Application No: 2025/62/93313/E

Address: 68, Oxford Road, Dewsbury, WF13 4EH

Dear Nicole,

Client Idris Mitha Patel		
Site Address 68 Oxford Road, Dewsbury, WF13 4EH		
Project Description Internal Alteration and Extension		
Status Planning		
Date November 2025	Drawn EB	Checked JE
Drawing Proposed Plans & Elevations	Scale # A1	Scale 1:100
Drawing No. 3665 (0-) 02	Revision B

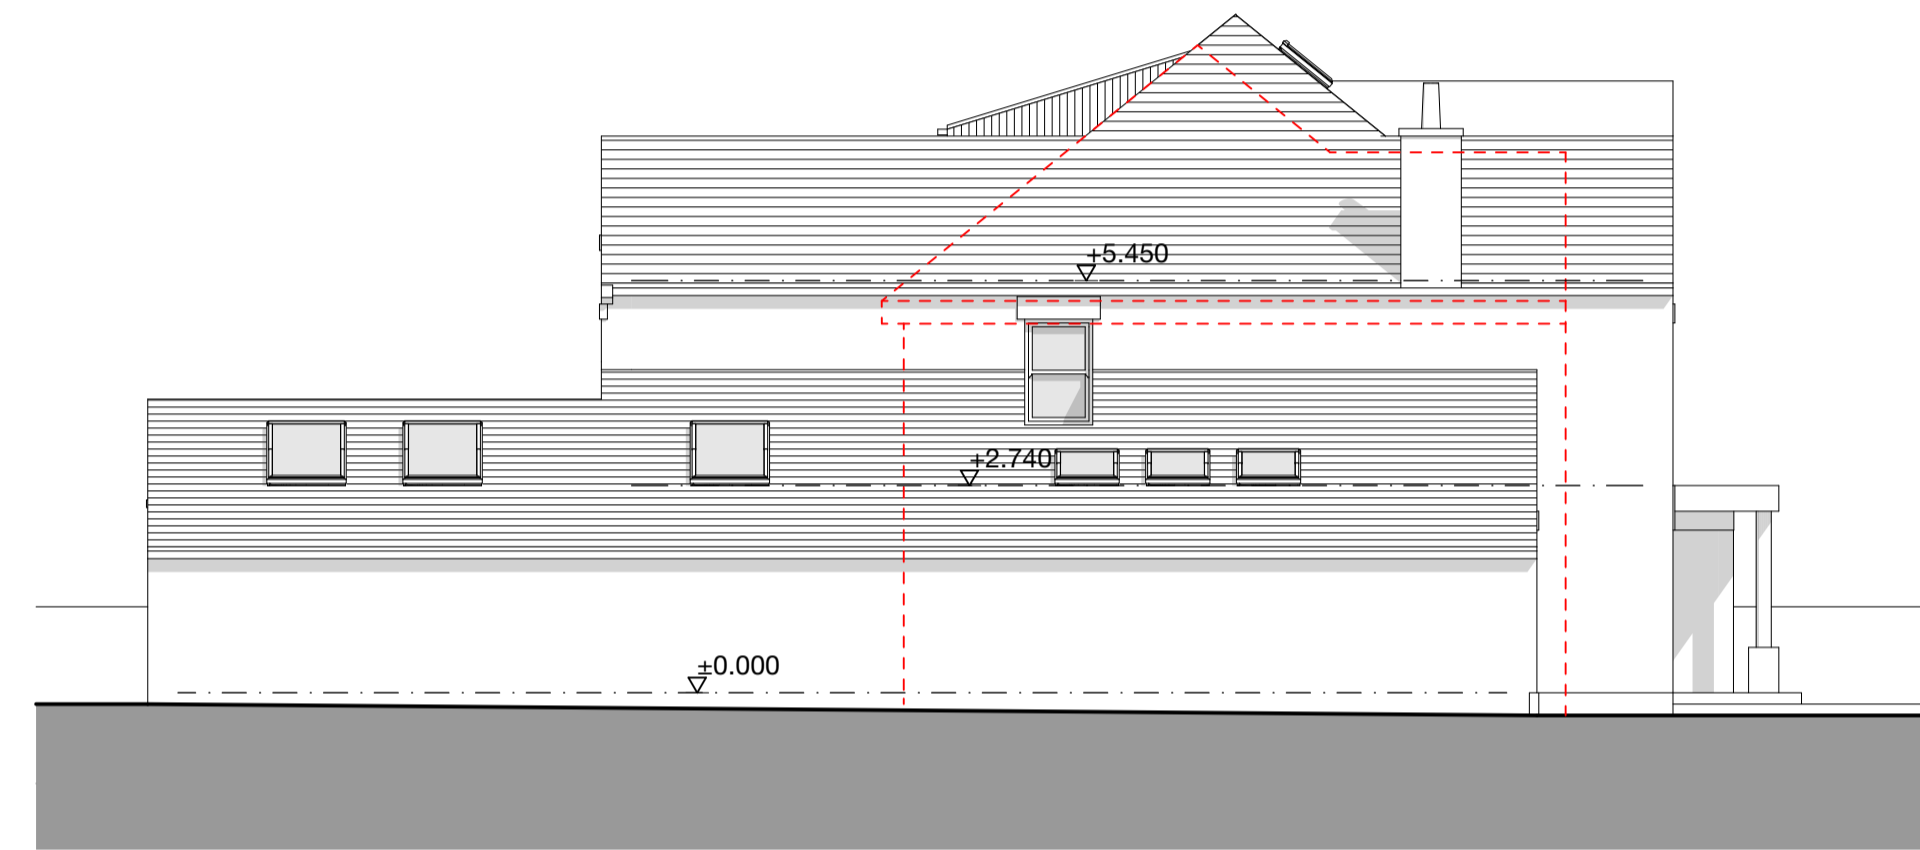
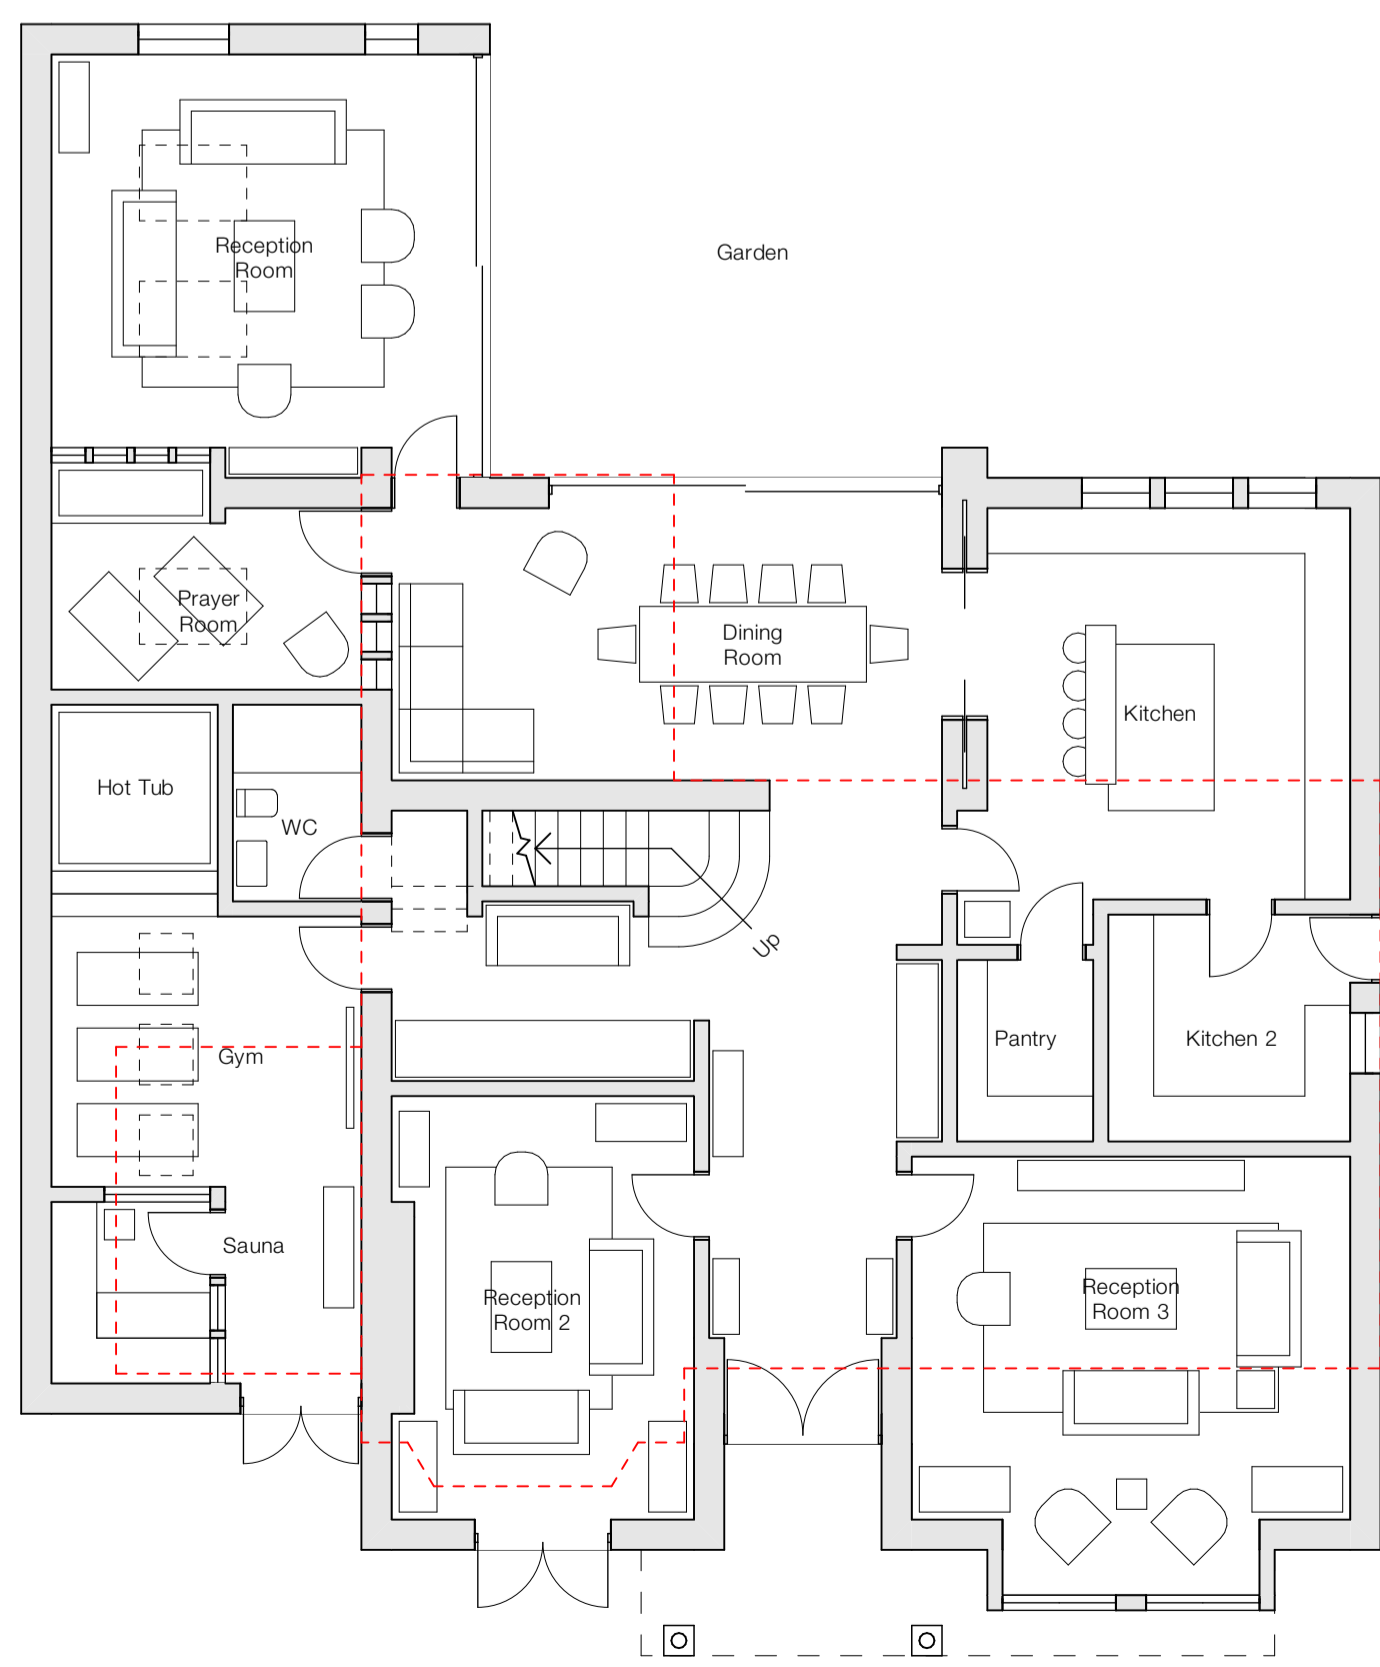
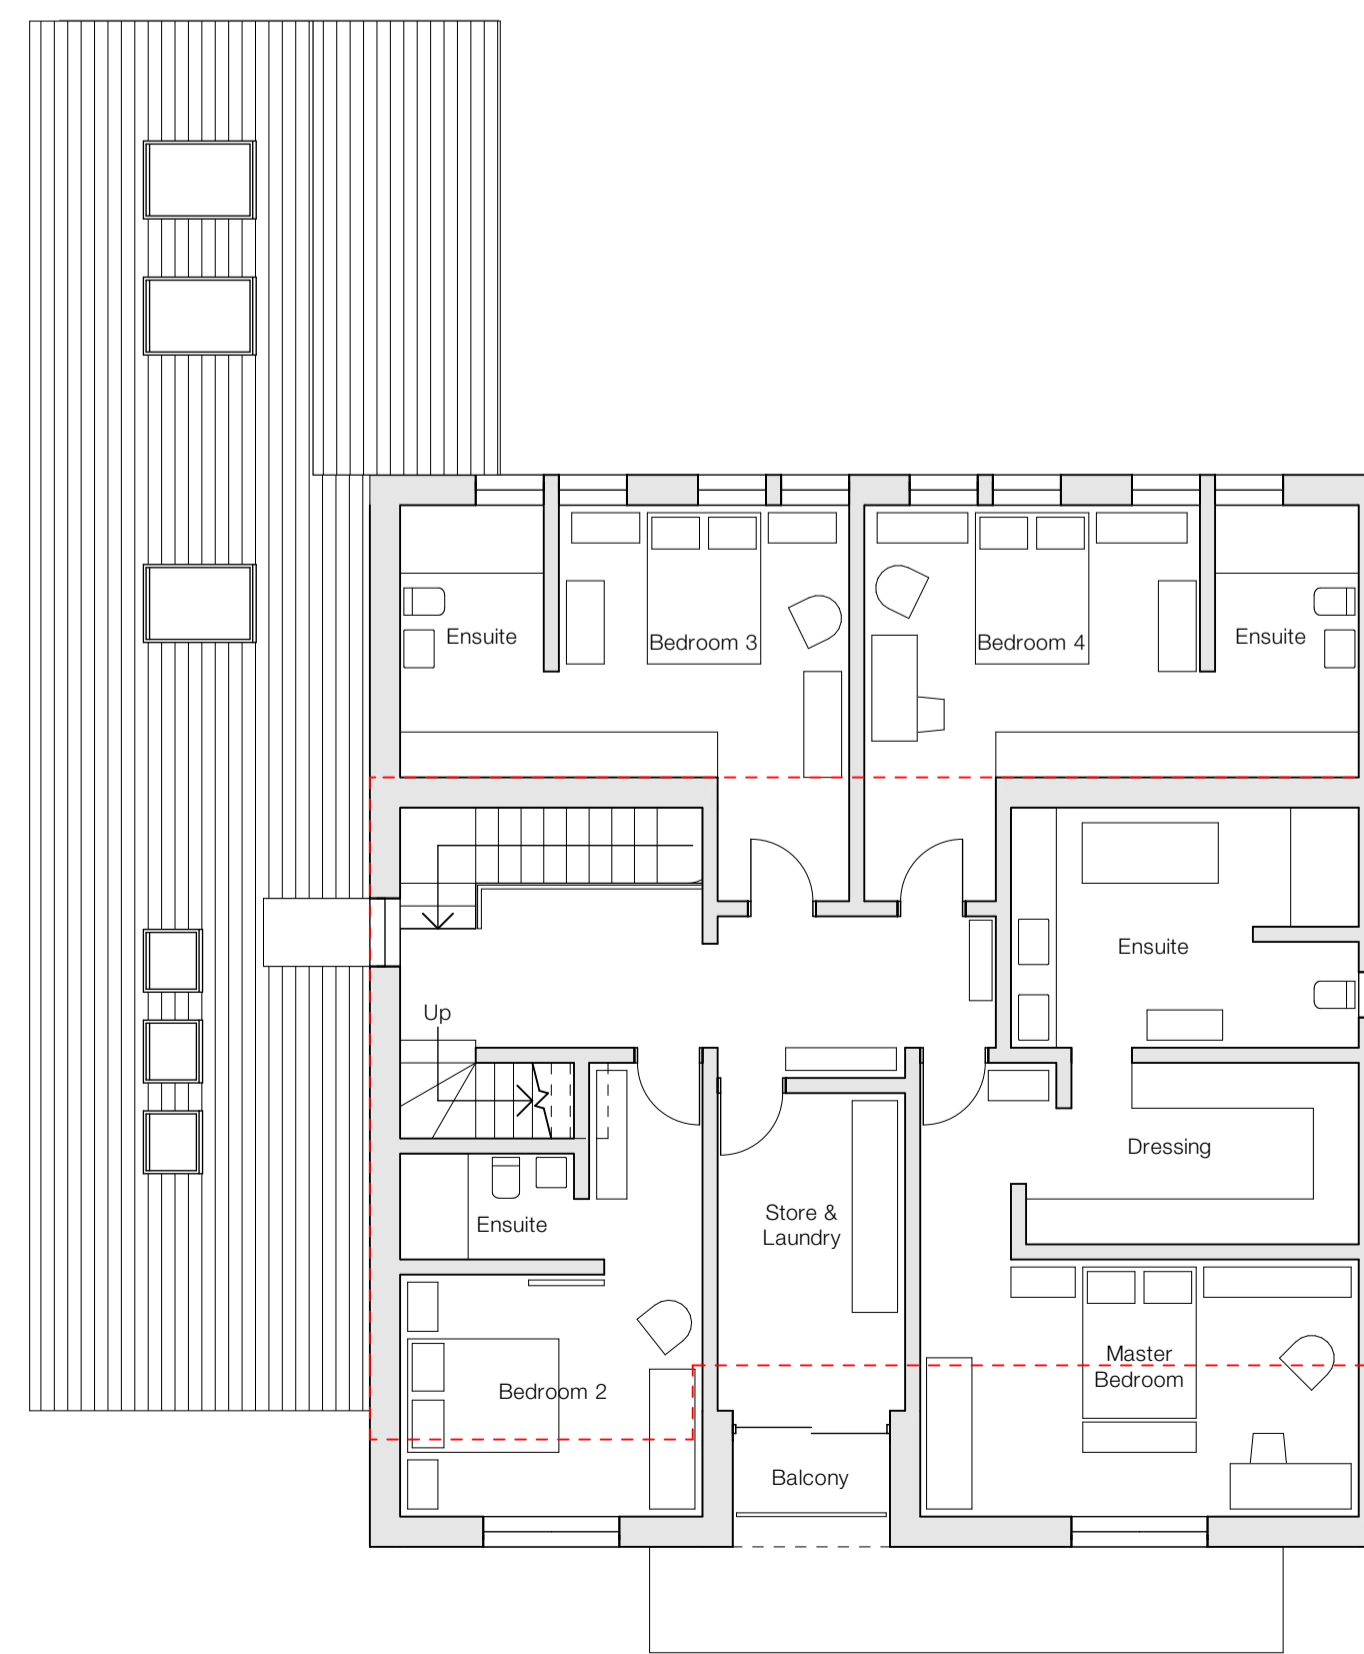
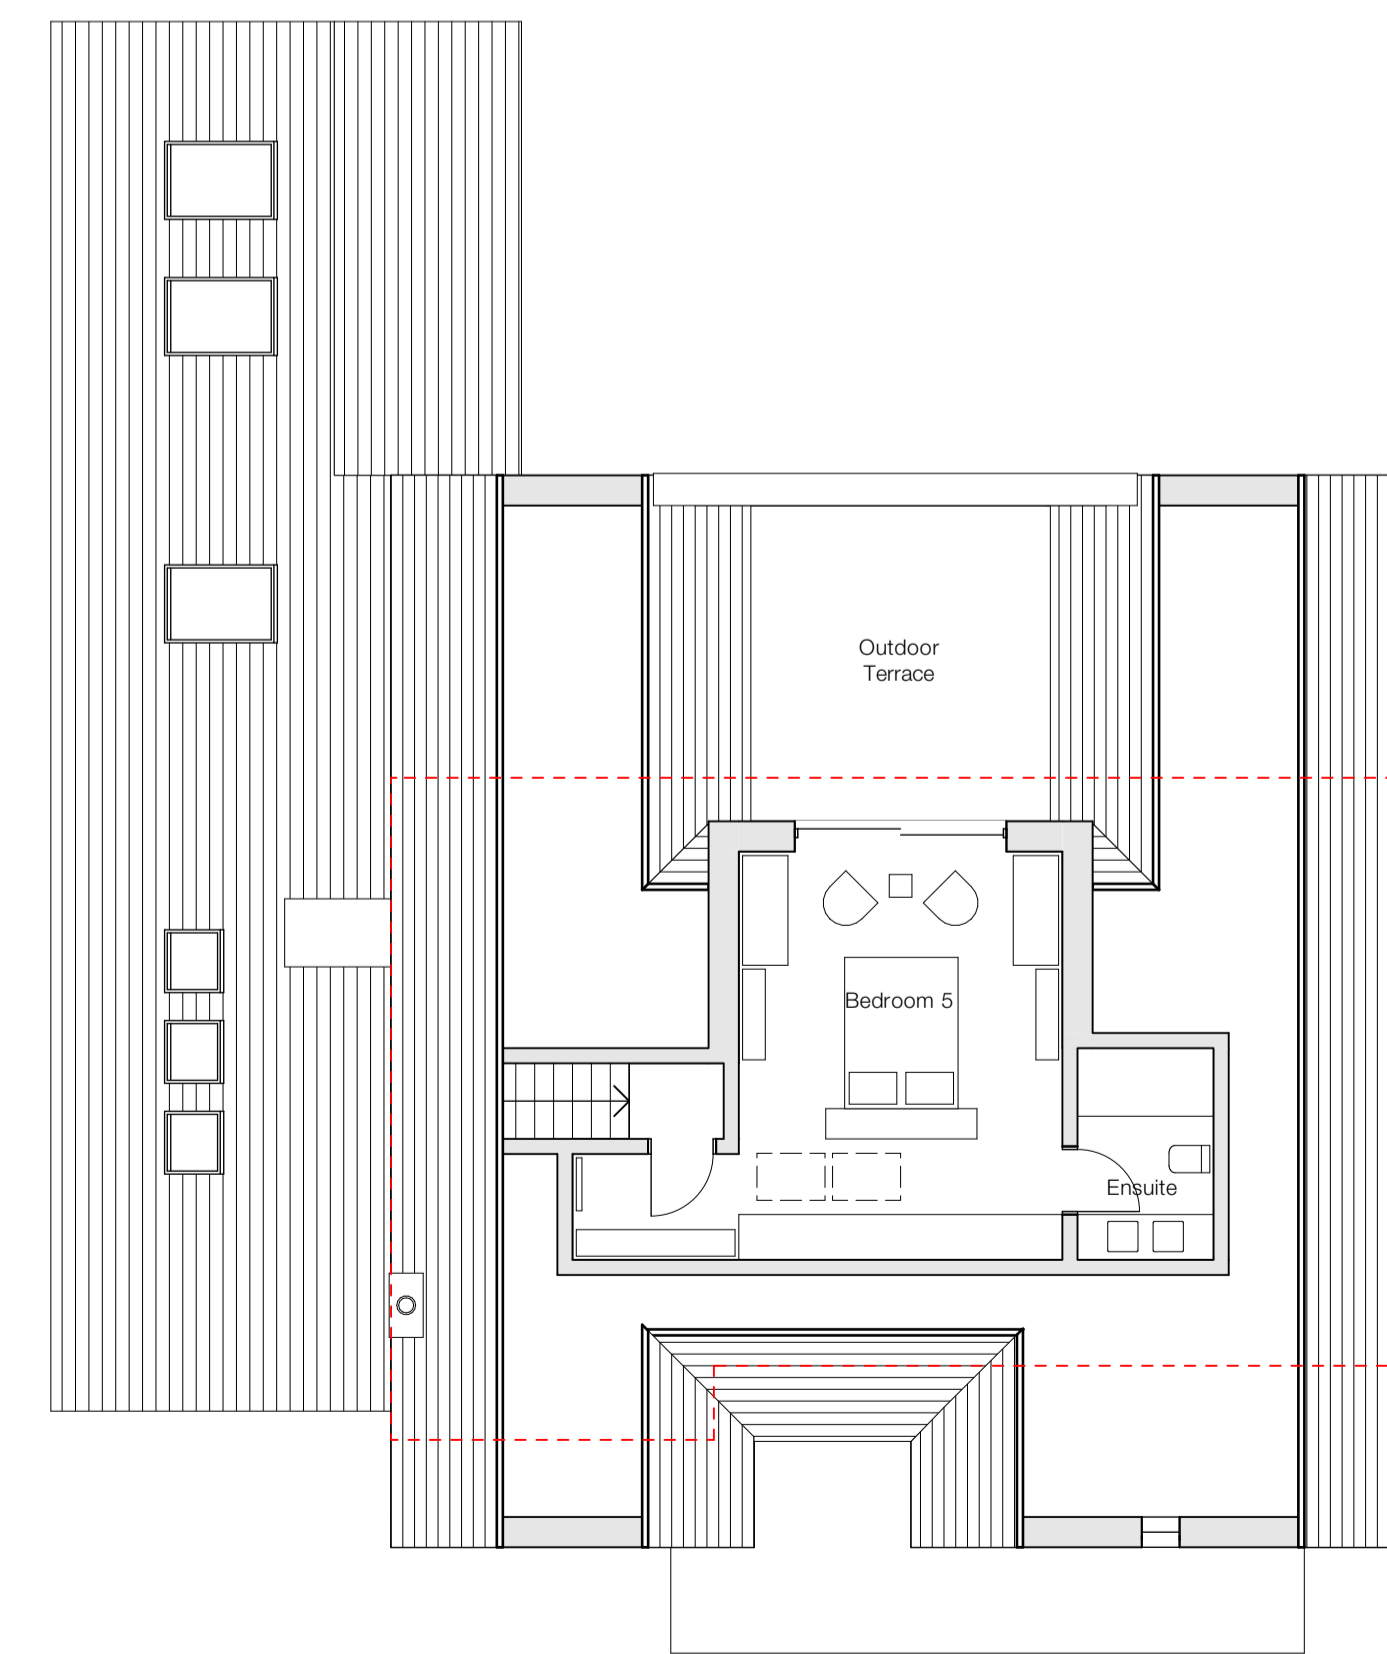
- A two-storey rear extension
- A single-storey rear extension
- Multiple balconies
- Increased height and bulk across the full rear elevation

The balconies are elevated and rear-facing, and my property at 2 Reservoir Street sits directly behind the site, meaning the proposals would enable direct overlooking into private rear garden space.

No meaningful mitigation (such as obscure screening or balcony redesign) is proposed, and reliance on existing trees is unreliable given seasonal changes.

The Planning Statement concludes that the extensions would not be overbearing due to retained distances and roof design. However, this underestimates the impact of the combined height, depth and mass of the rear extensions when viewed from Reservoir Street.

The cumulative built form would create a dominant rear elevation, resulting in a sense of enclosure and loss of outlook from neighbouring properties, including No. 2 Reservoir Street.

For these reasons, the application should be refused, or substantially redesigned, including the removal of rear-facing balconies and a reduction in rear extension scale.
